**NorthConnex Application Number: SSI 13\_6136**

Please find following my submission letter in relation to the exhibition of the EIS for the NorthConnex project.

M1-M2-5000-DR-UD-0556
NORTHERN VENTILATION FACILITY - LONG SECTION

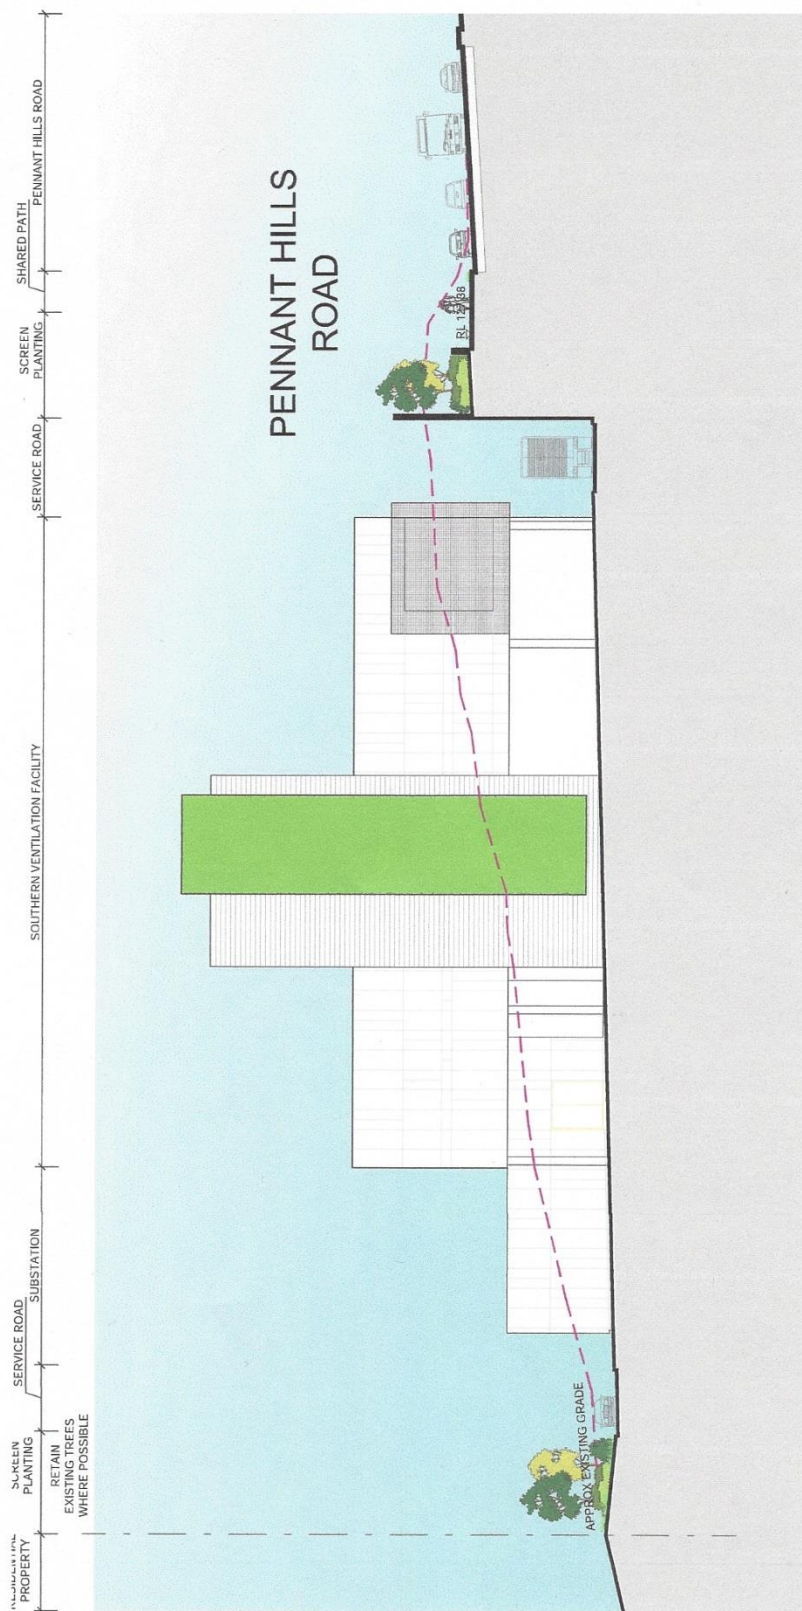
**b) The topography and climatic conditions at Wahroonga are unsuitable for the location of a (short) 23m stack**

The proposed northern ventilation stack is intended to be only 23m tall. The proposed stack site of 19 Woonona Avenue, Wahroonga is in a valley. At this location, the height of the stack would not clear the surrounding terrain and emissions would be inadequately dispersed.

One of the main principles in achieving the most effective dispersion of particulate matter relates to stack height. If the proposed northern stack was substantially higher, the pollution would disperse far more effectively into the atmosphere and reduce the exposure at ground level.

In the EIS, Transurban chose the location for the northern stack at Wahroonga based on satellite imagery. However this only measures distances to 6m, which is insufficient detail for assessing this as the best location.

By comparison, the ventilation stack for the Cross City tunnel (2.1km long) is 65m high. The height of this stack appears to be a far better design option.
